CITY OF ALBUQUERQUE  
PLANNING DEPARTMENT  
October 20, 2010  
DRB Comments

**RE: Tract C-6, The Gardens on the Rio Grande, unit 1**

CITY OF ALBUQUERQUE  
PLANNING DEPARTMENT  
June 22, 2011  
DRB Comments

**RE: Tract C-6, The Gardens on the Rio Grande Unit 1**

PLAT FOR
 TRACT C6-A, C6-B & C6-C
 THE GARDENS ON THE RIO GRANDE
 UNIT 1
 M.R.G.C.D. MAP NO. 38
 WITHIN THE
 TOWN OF ALBUQUERQUE GRANT
 PROJECTED SECTION 13
 TOWNSHIP 10 NORTH, RANGE 2 EAST, N.M.P.M.
 CITY OF ALBUQUERQUE
 BERNALILLO COUNTY, NEW MEXICO
 JUNE, 2011

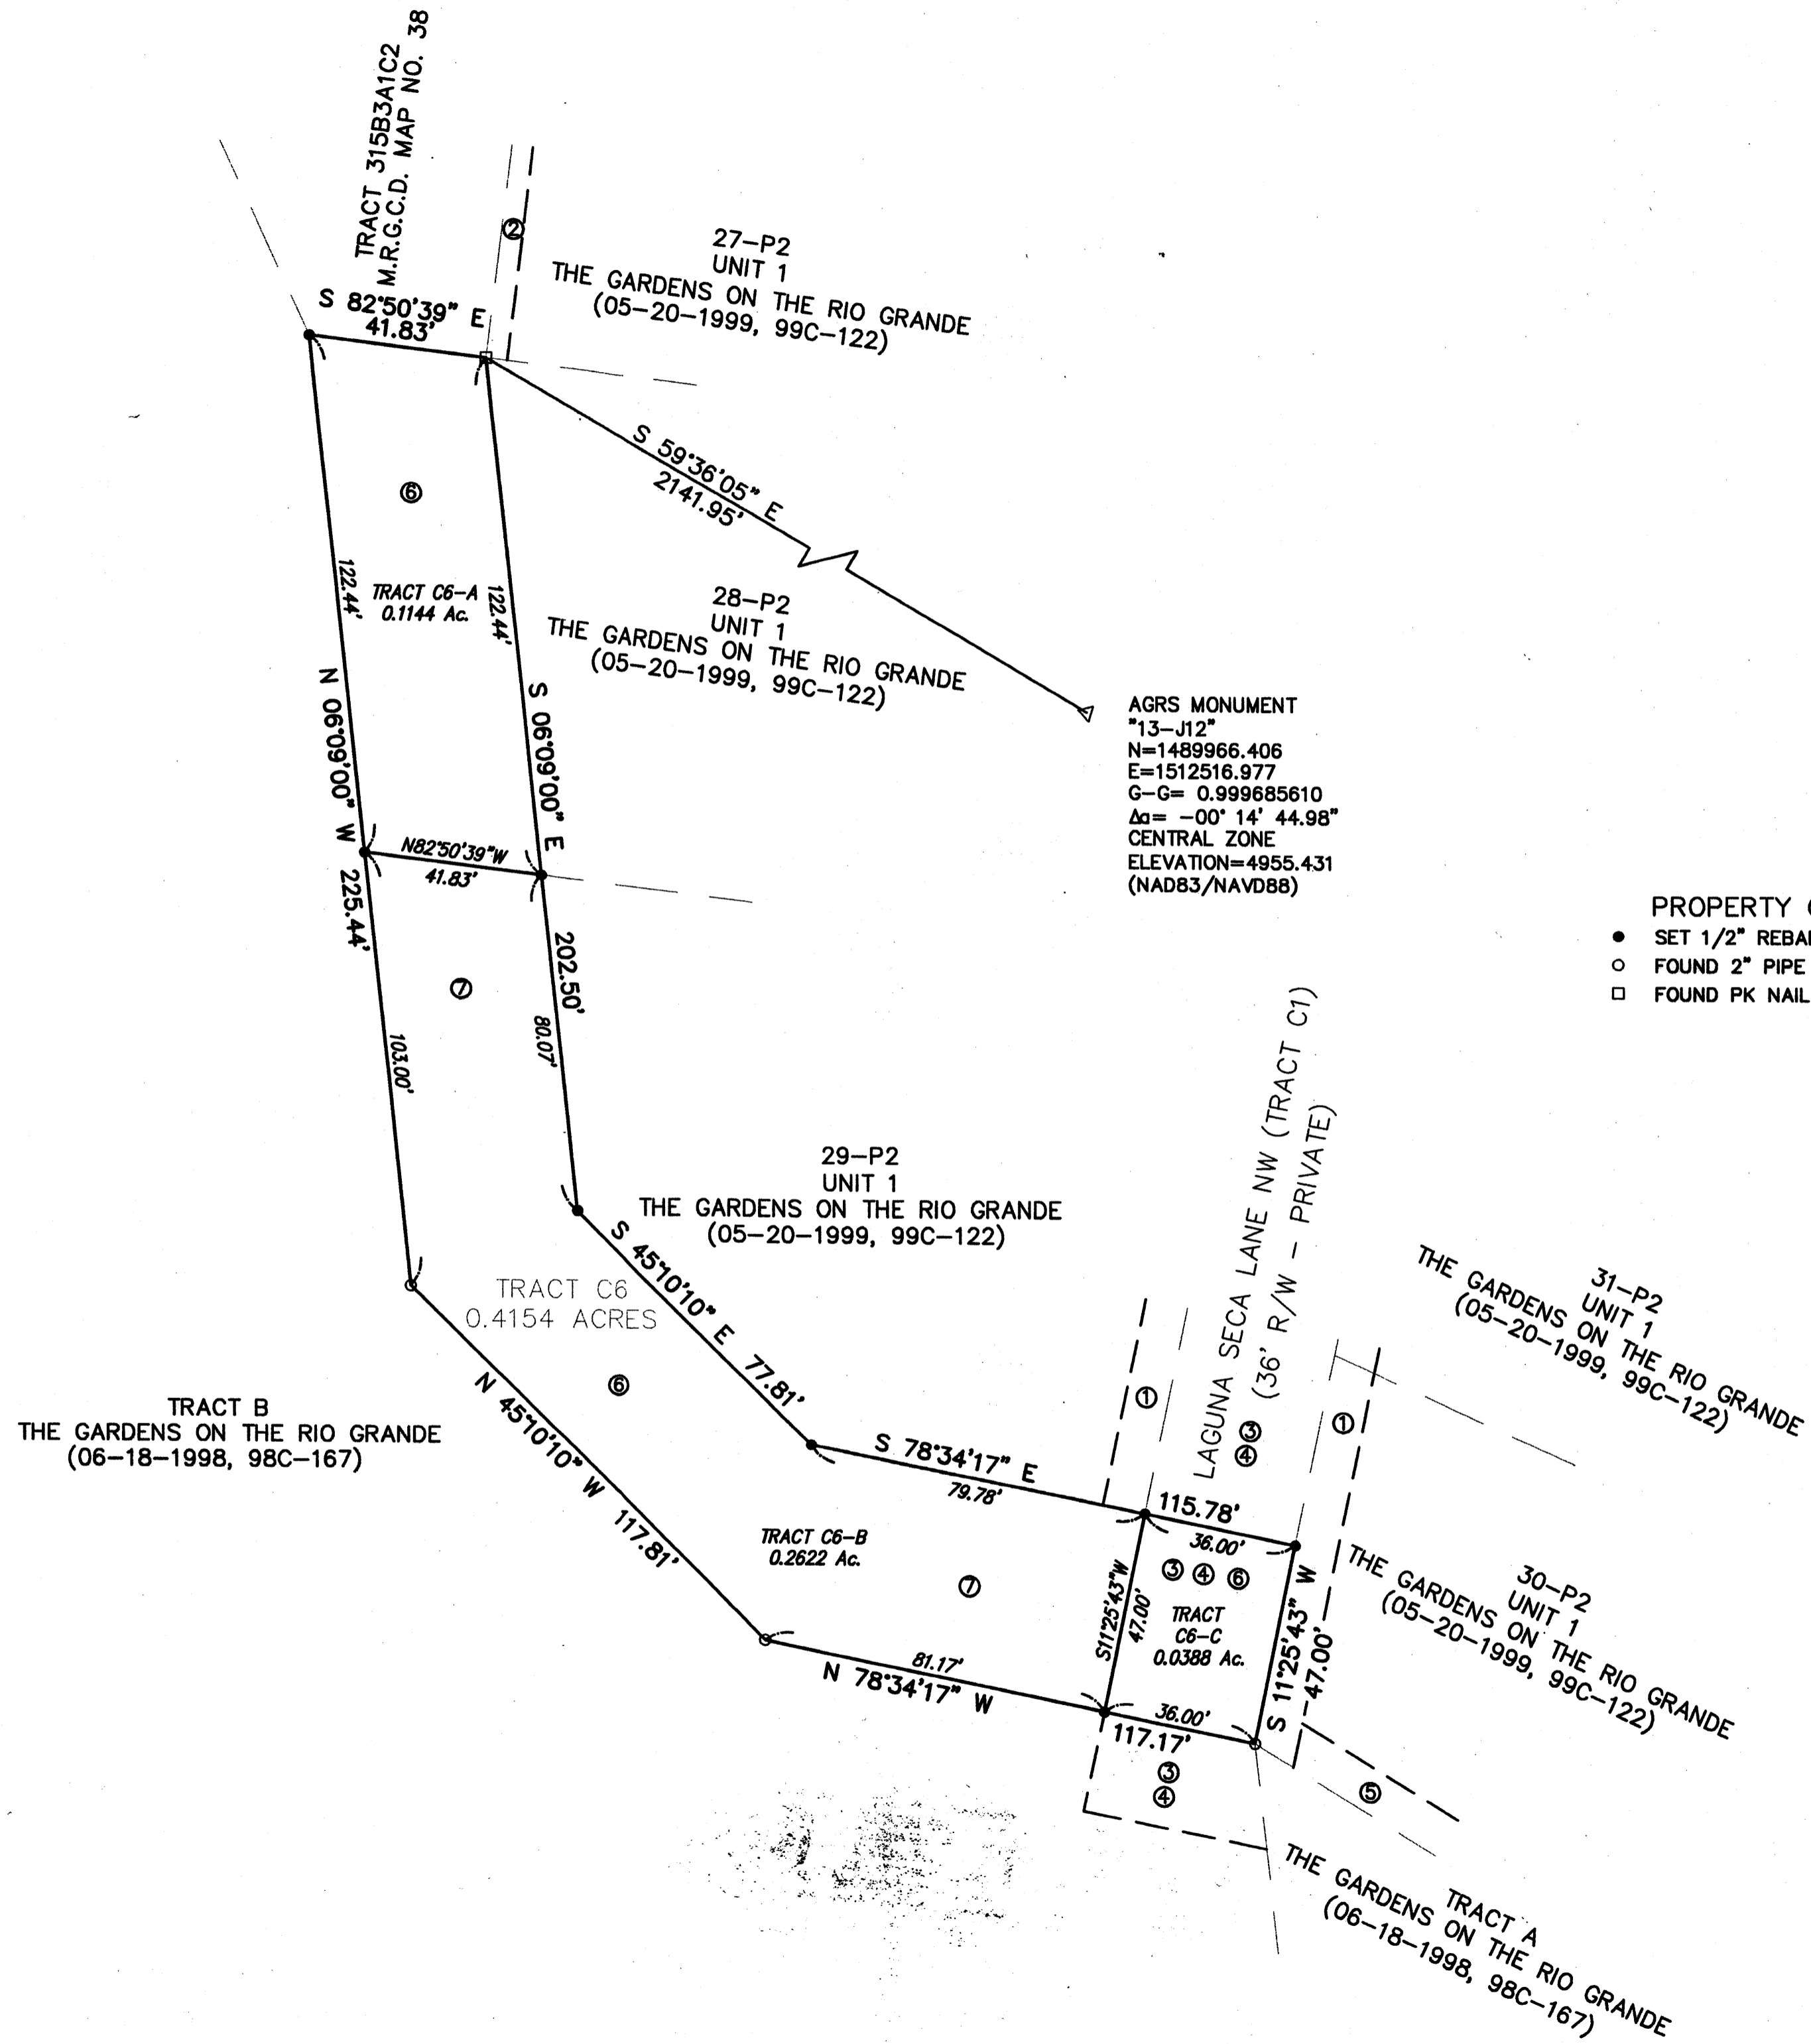
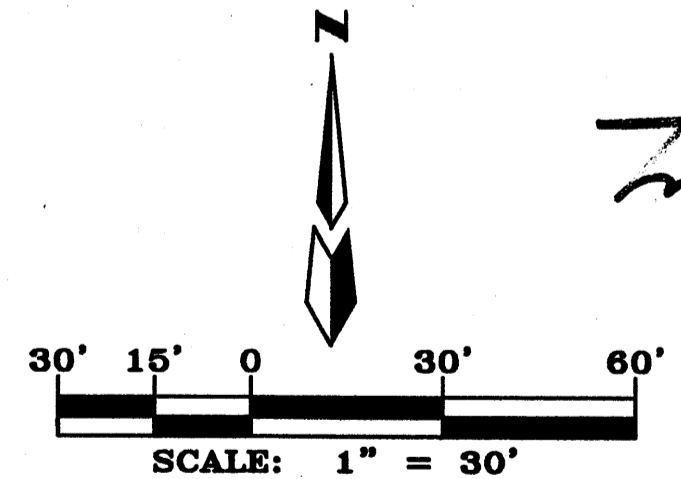
The easement on the proposed plat need to be clarified.

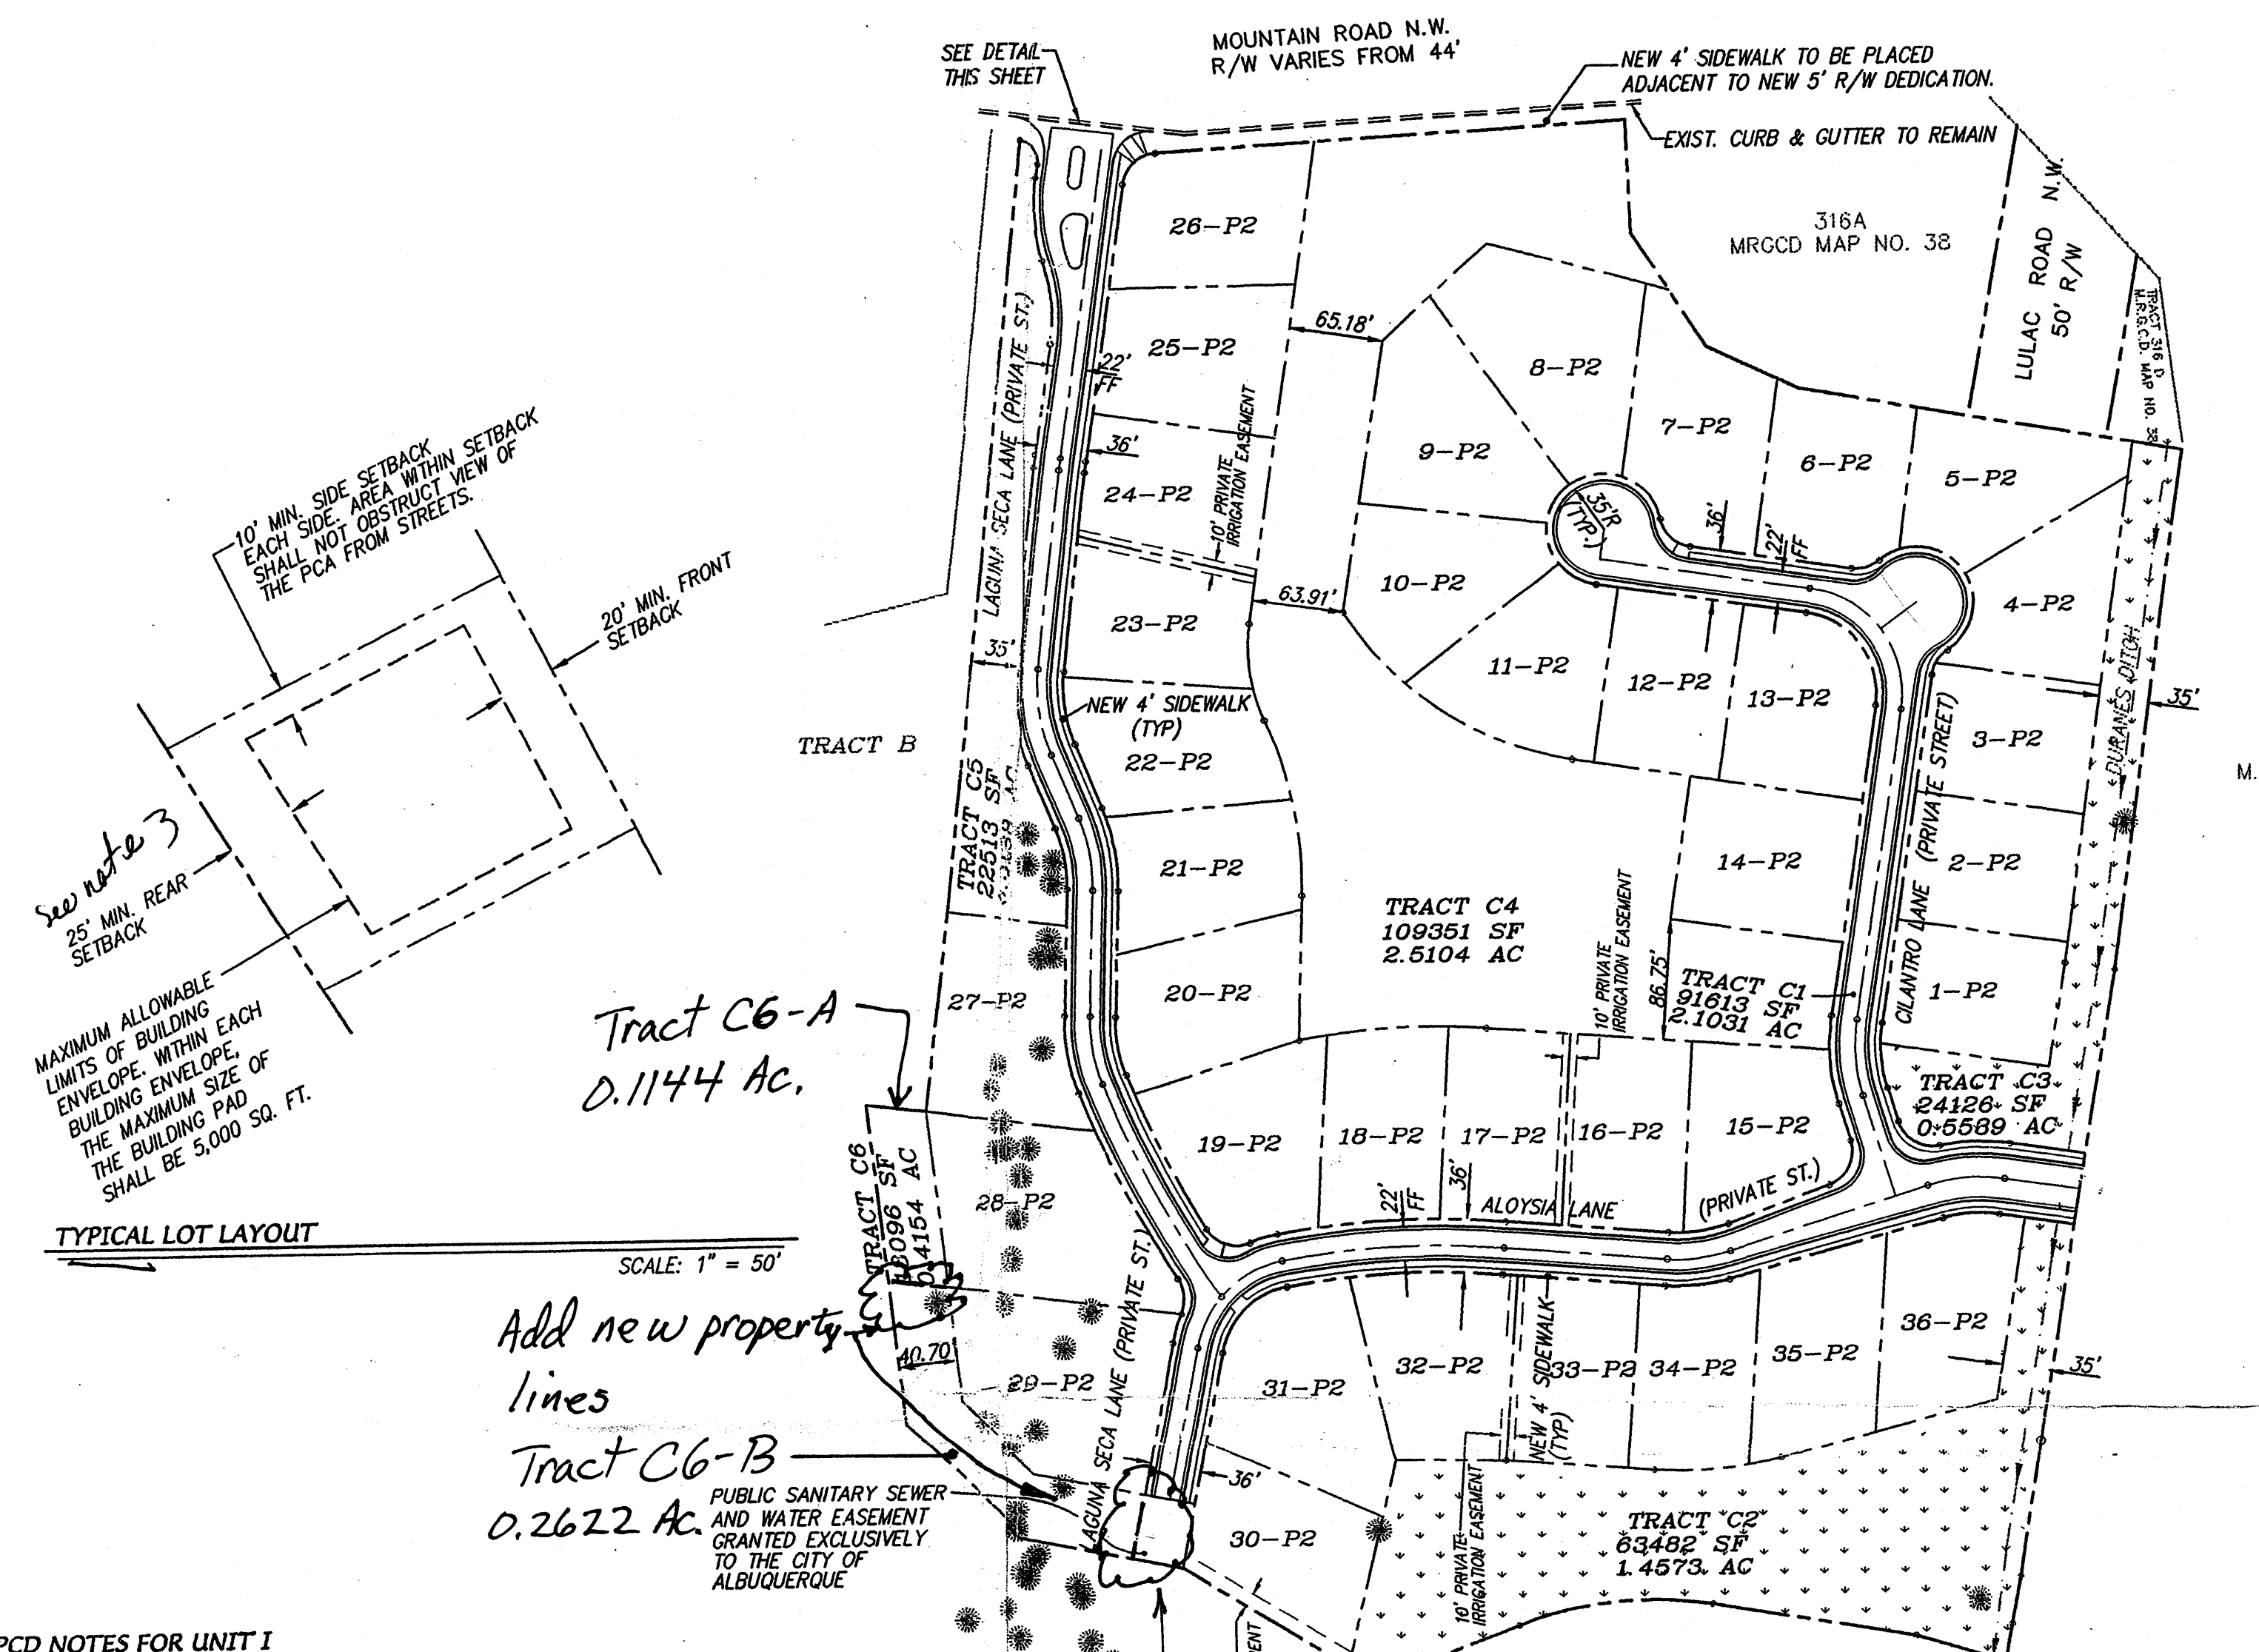
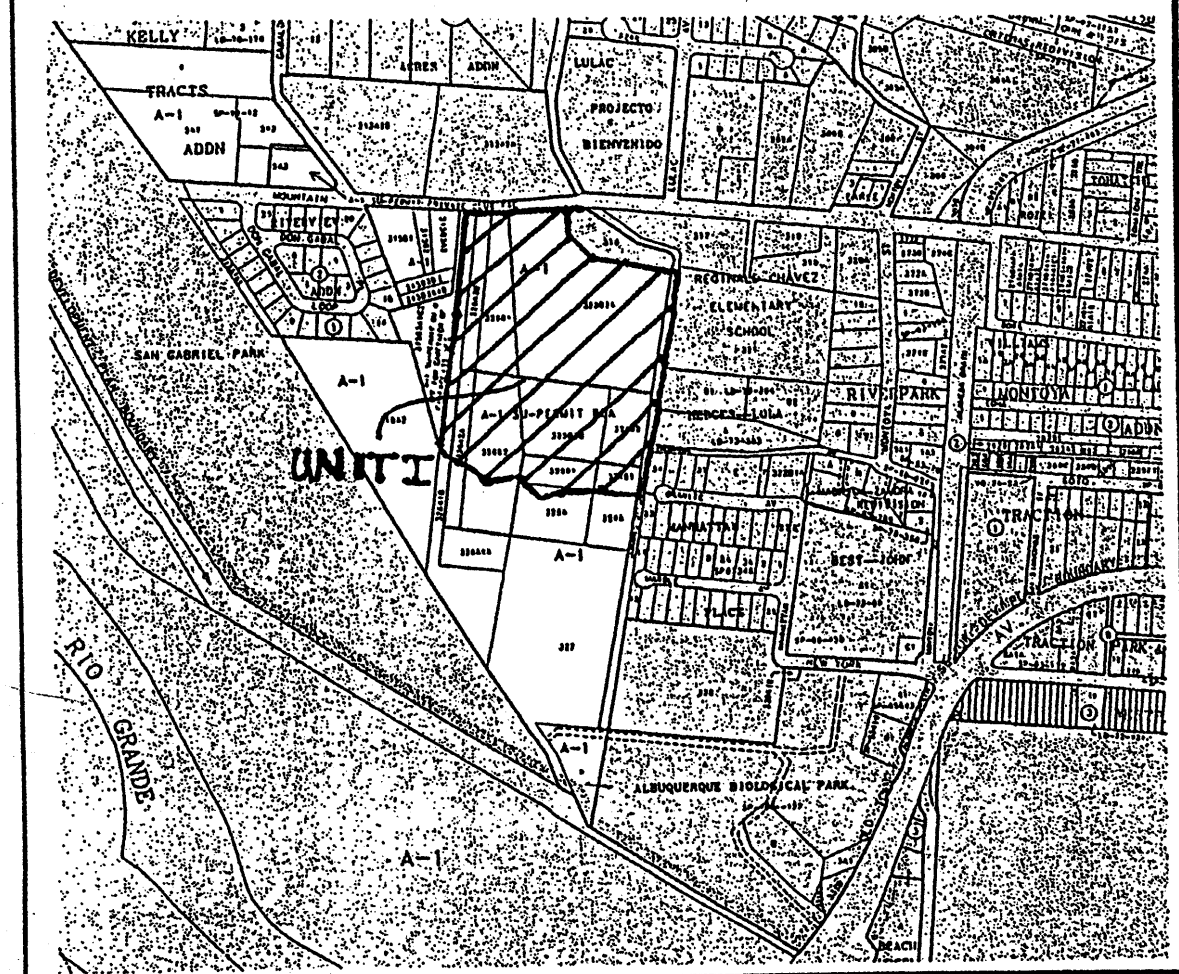
Site Plan Note No. 12 needs to be amended to reflect new tract numbers; please be sure to make all of the site plan (particularly the lower left corner) readable and reproducible.
